Re: Mixed Use Development at Burroway Road, Wentworth Point (SSD 6387)

Response to Relevant 'Water Management and Flooding' Matters in Auburn City Council Comments (c/- NSW Planning & Environment, 31 July 2014)

Advice on Stormwater Management at Burroway Road / Hill Road Intersection

C4.01

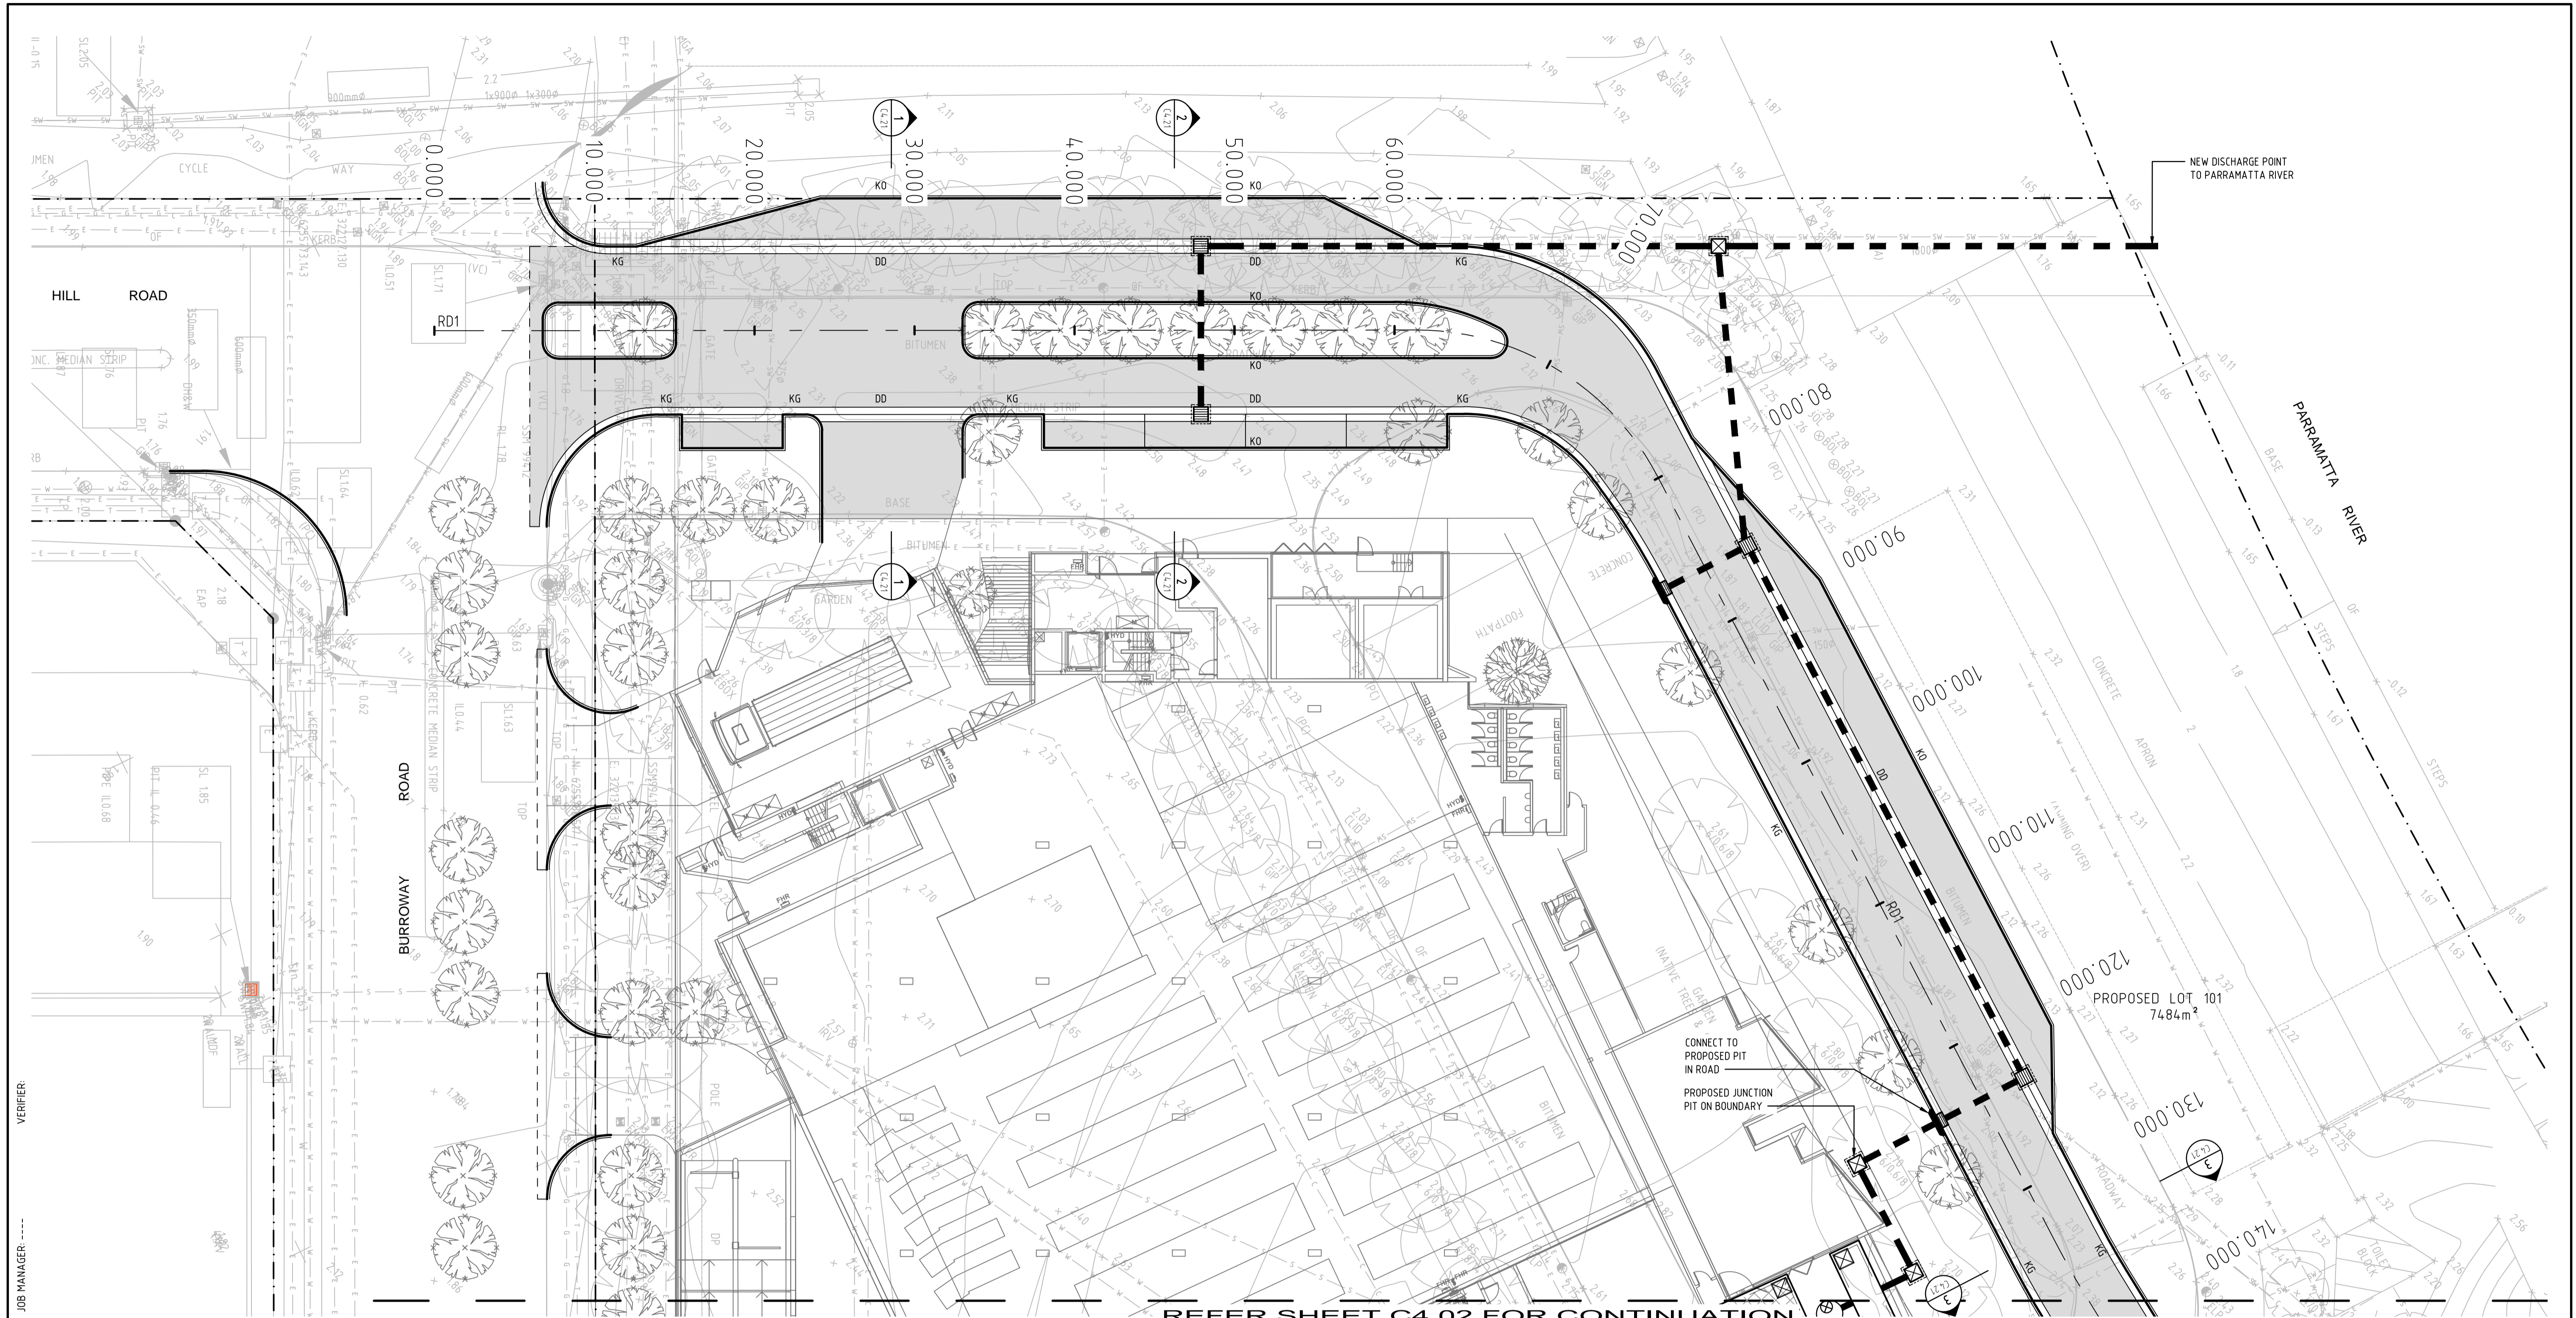
Northrop has reviewed background information (including the calculations for the existing contributing catchments, prepared by Brown Consulting – copy attached). The following comments are provided to confirm design measures to convey runoff from the north-eastern corner of the subject intersection to the Parramatta River. We refer also to the attached marked-up sketch diagram, prepared by Northrop.

- The design proposes a conventional road intersection (in lieu of the existing layback and driveway). This will improve the levels for passage of overland flow north of Burroway Road – along the proposed extension to Hill Road.

- 4. Overland flow into the Hill Road extension will occur in the event of blockage of the existing pit (located on the north-eastern corner of the intersection), and in the event it ponds up to approximately 210mm.

- 5. The proposed road cross-section has capacity to convey approximately 2.8m³/s of overland flow. This equates to the gap flow Brown Consulting has calculated for the 100-year ARI event

- The current design incorporates measures to manage overflow away from the north-eastern corner of the Burroway / Hill Road intersection.
- The incorporation of intermittent kerbs along the western side of the parking / set-down area to the proposed Hill Road extension will lower the level before overflow will continue to the Parramatta River.
- These principles will need to be considered in the stormwater management strategy for the overall Wentworth Point UAP – being developed by Brown Consulting (on behalf of UrbanGrowth NSW). In this regard we note the current design information indicates Burroway Road will continue to drain further west to the proposed overland flow path (west of Hill Road) – thereby further relieving stormwater runoff from the subject intersection.

DRAWING NUMBER	REVISION
C4.11	1

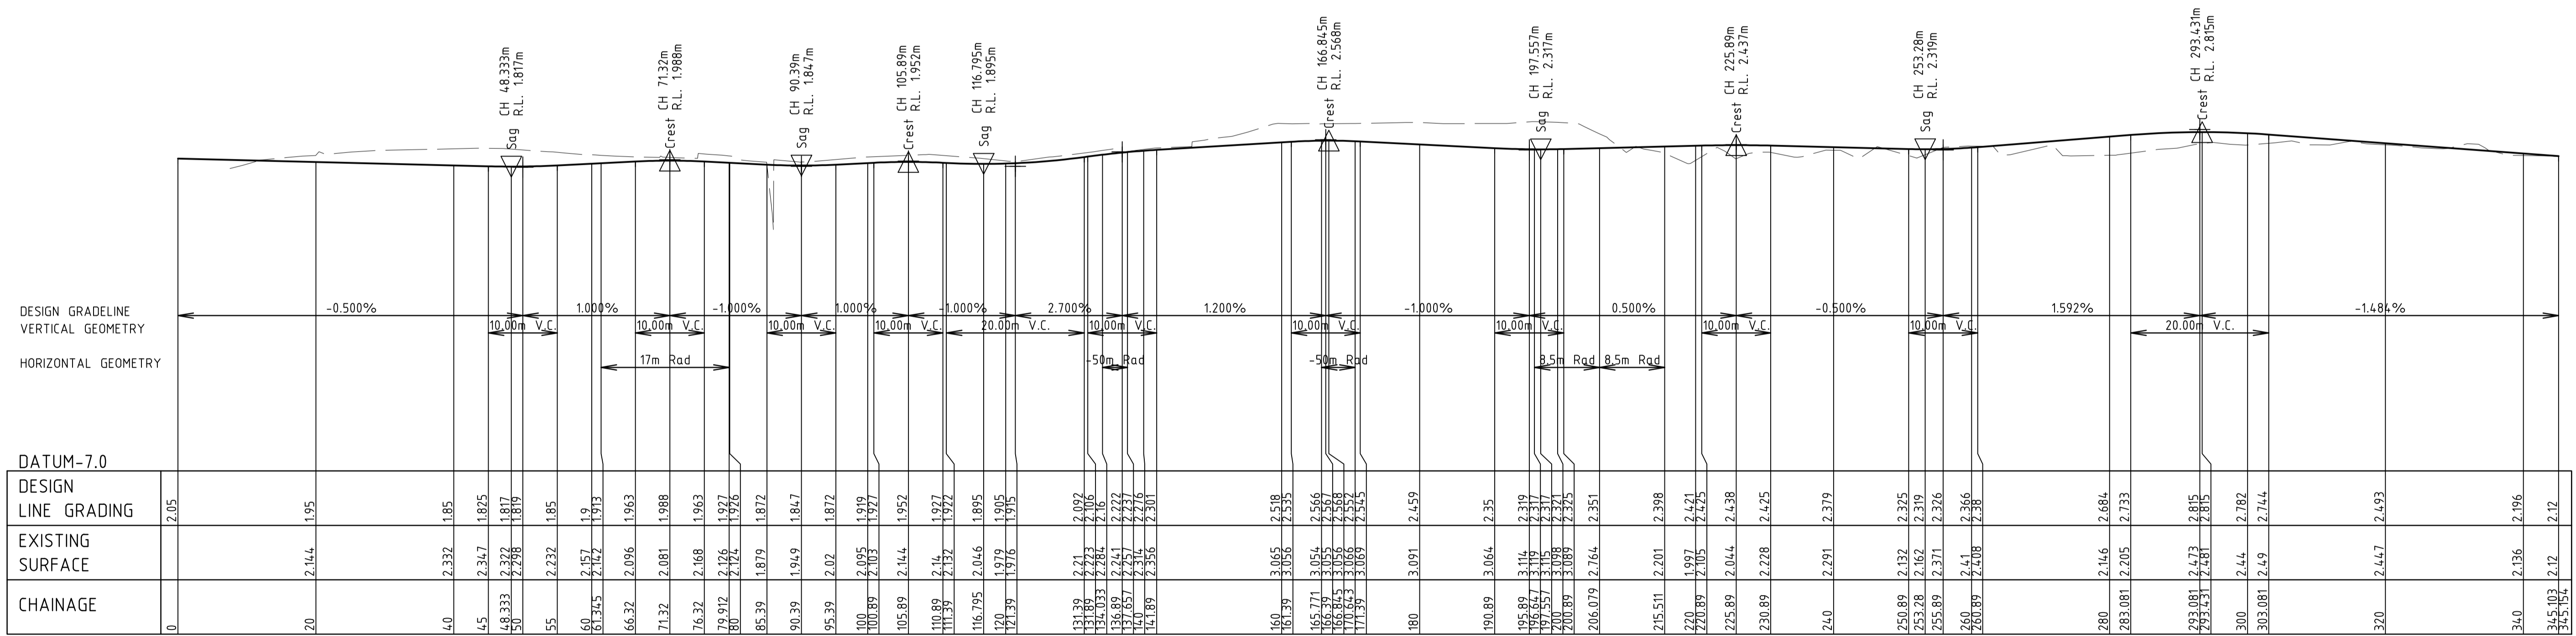
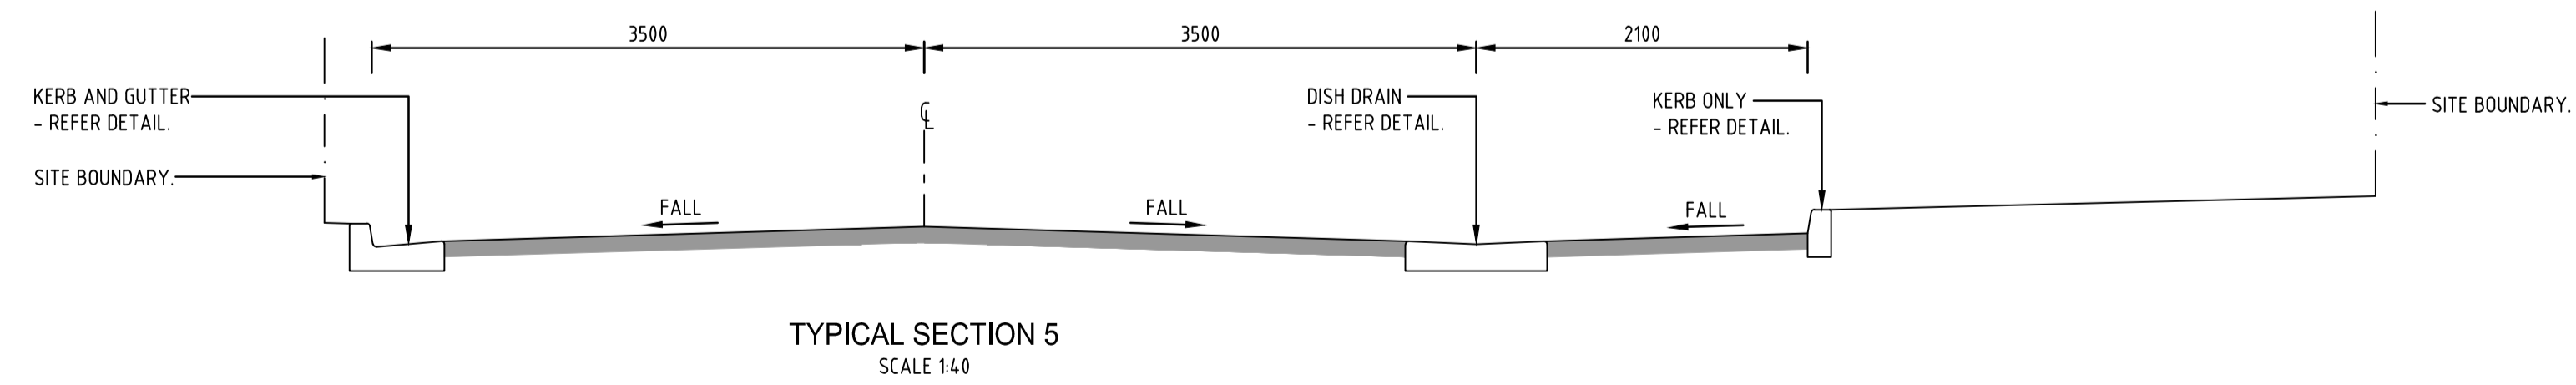
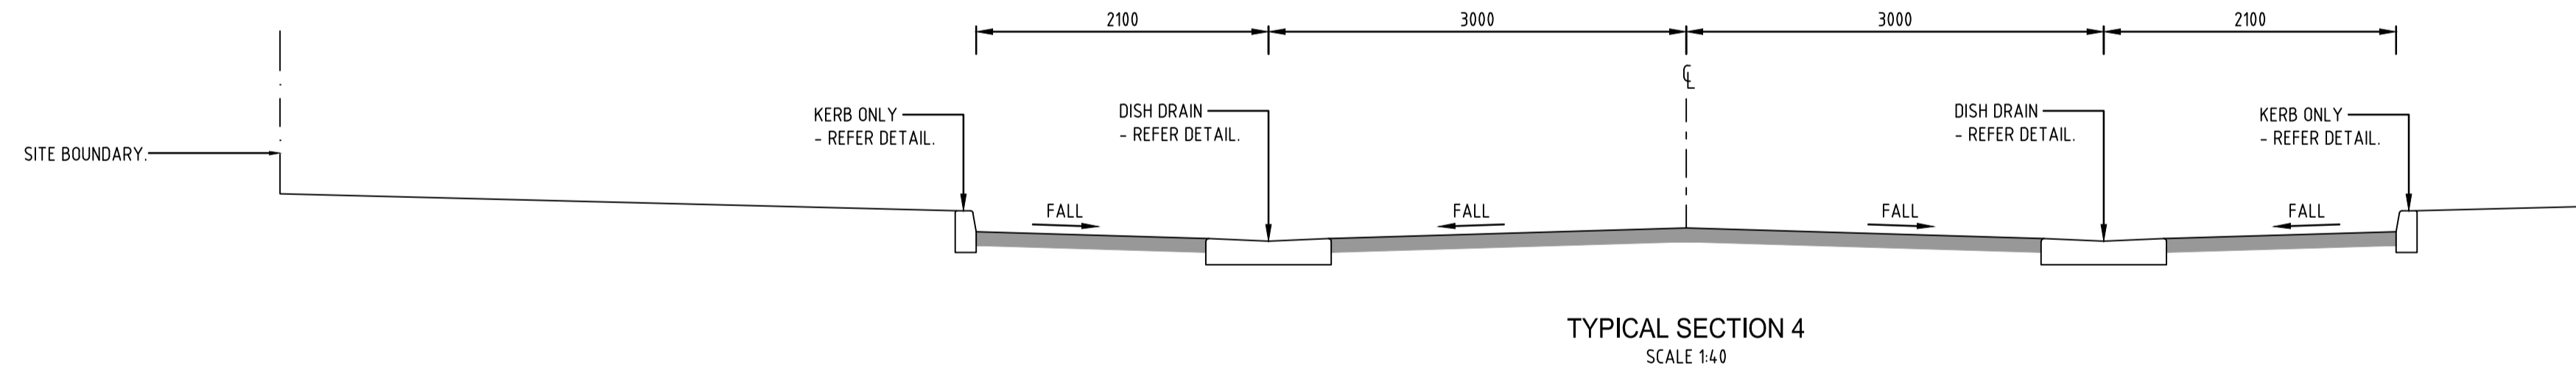
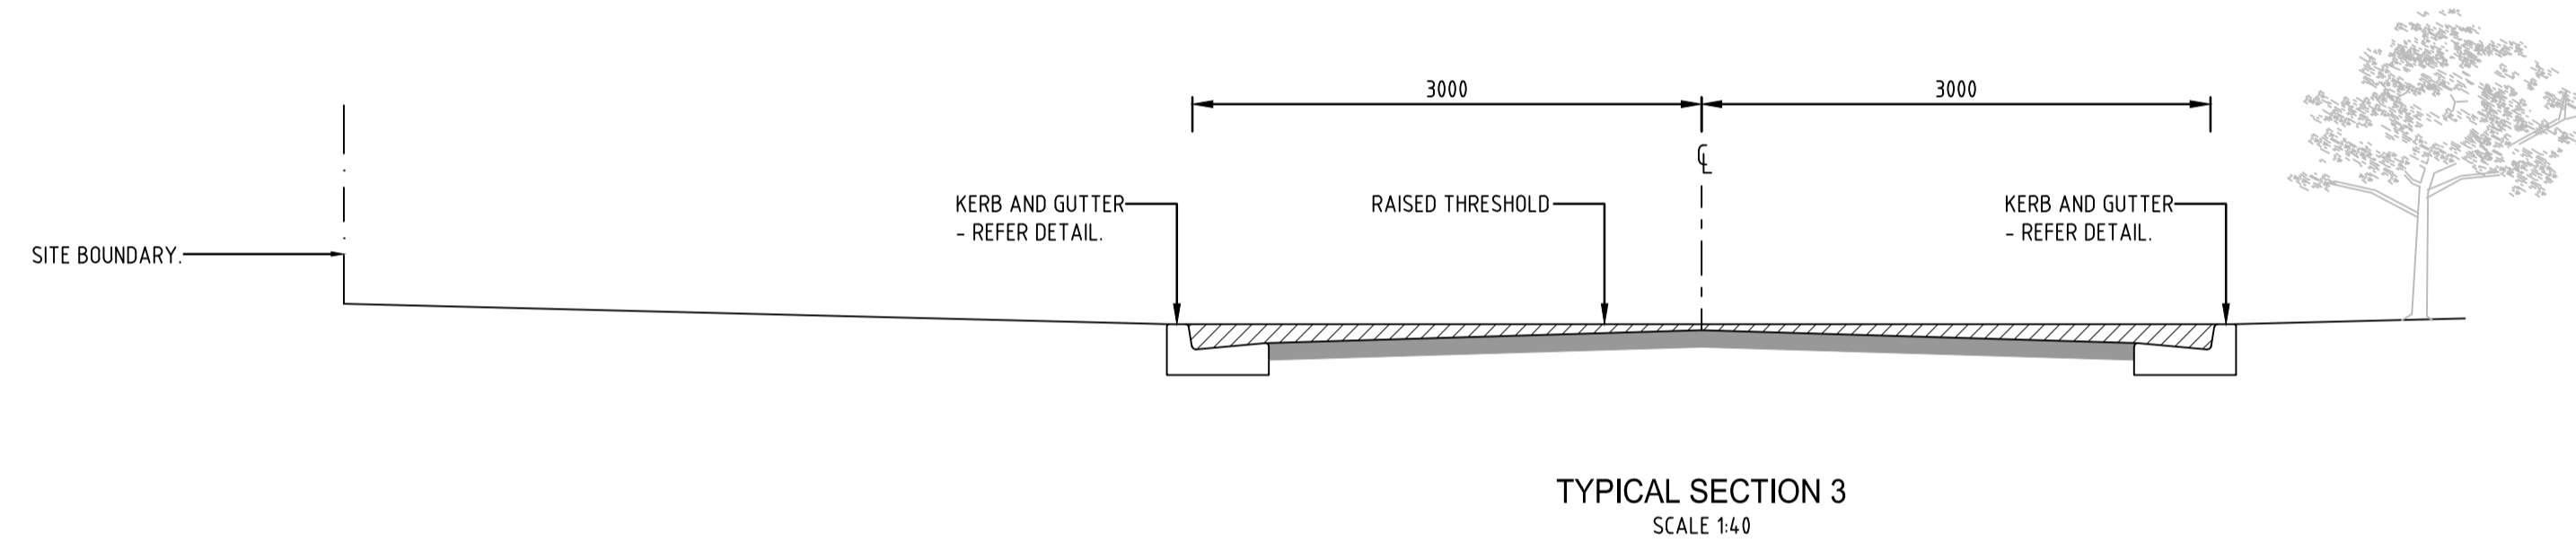
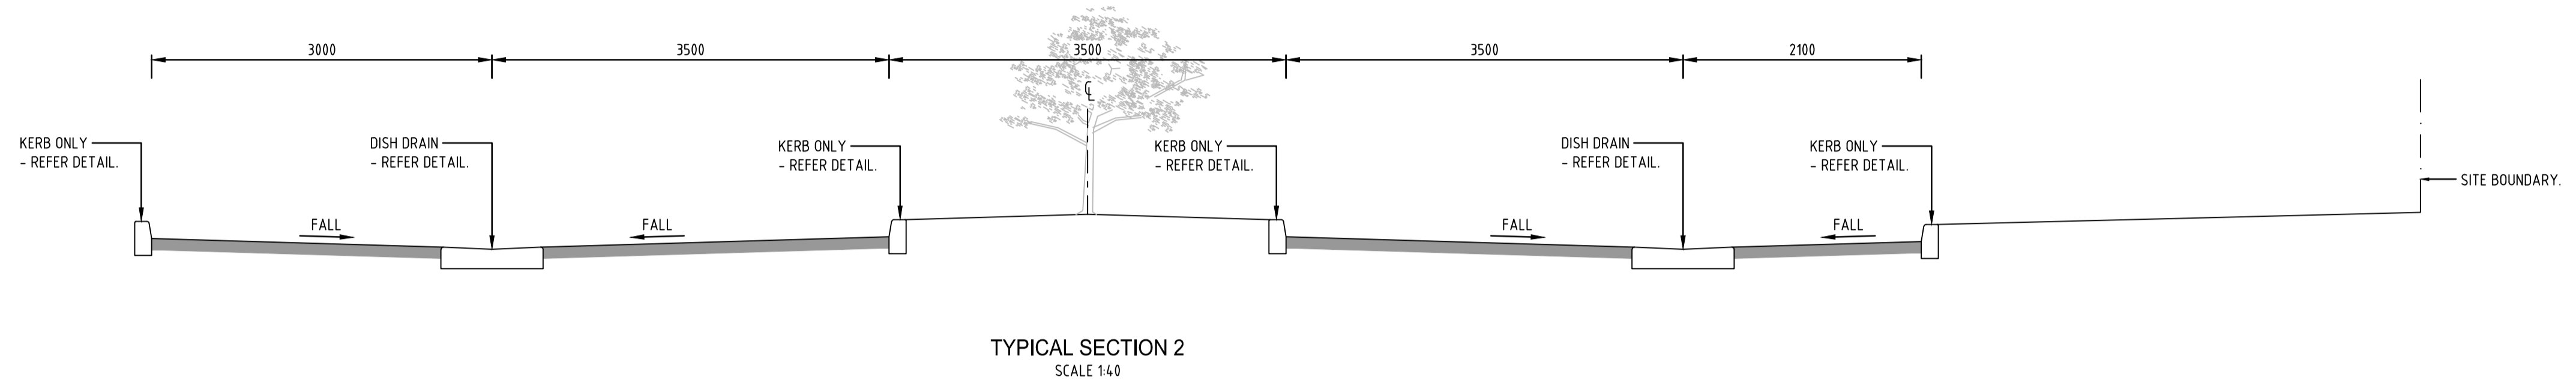
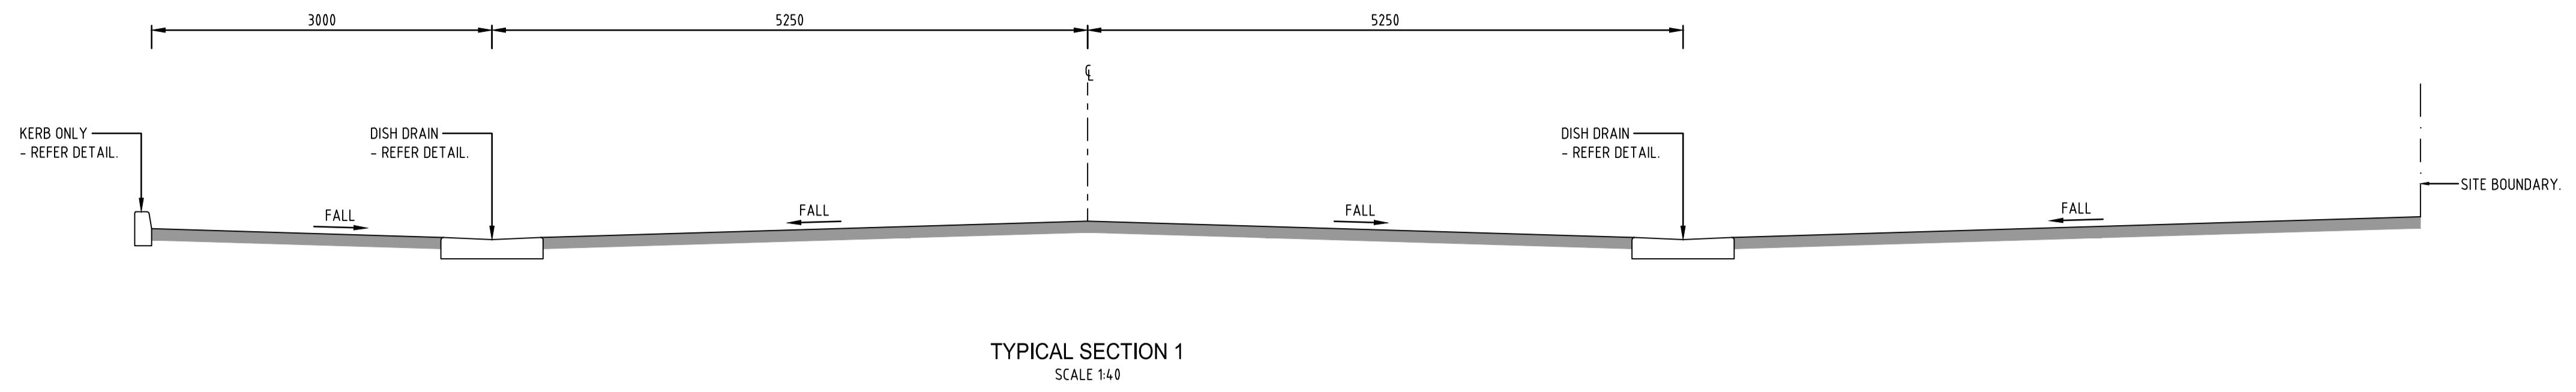
- 2. The longitudinal section of the proposed extension to Hill Road (attached) promotes overflow in a northerly direction from the intersection to a point approximately 50m north of the intersection.

6. The relief point for overflow from the proposed Hill Road extension to the River is at proposed Road Chainage 50 (approx.). Intermittent kerbs along the western edge of the parking / setdown area (in lieu of continuous, full-height kerb) present an opportunity to enable overflow at pavement level (rather than top of kerb, i.e. 150mm higher). This would be subject to SOPA accepting intermittent kerbs (in lieu of barrier kerb), adjacent the set-down area.
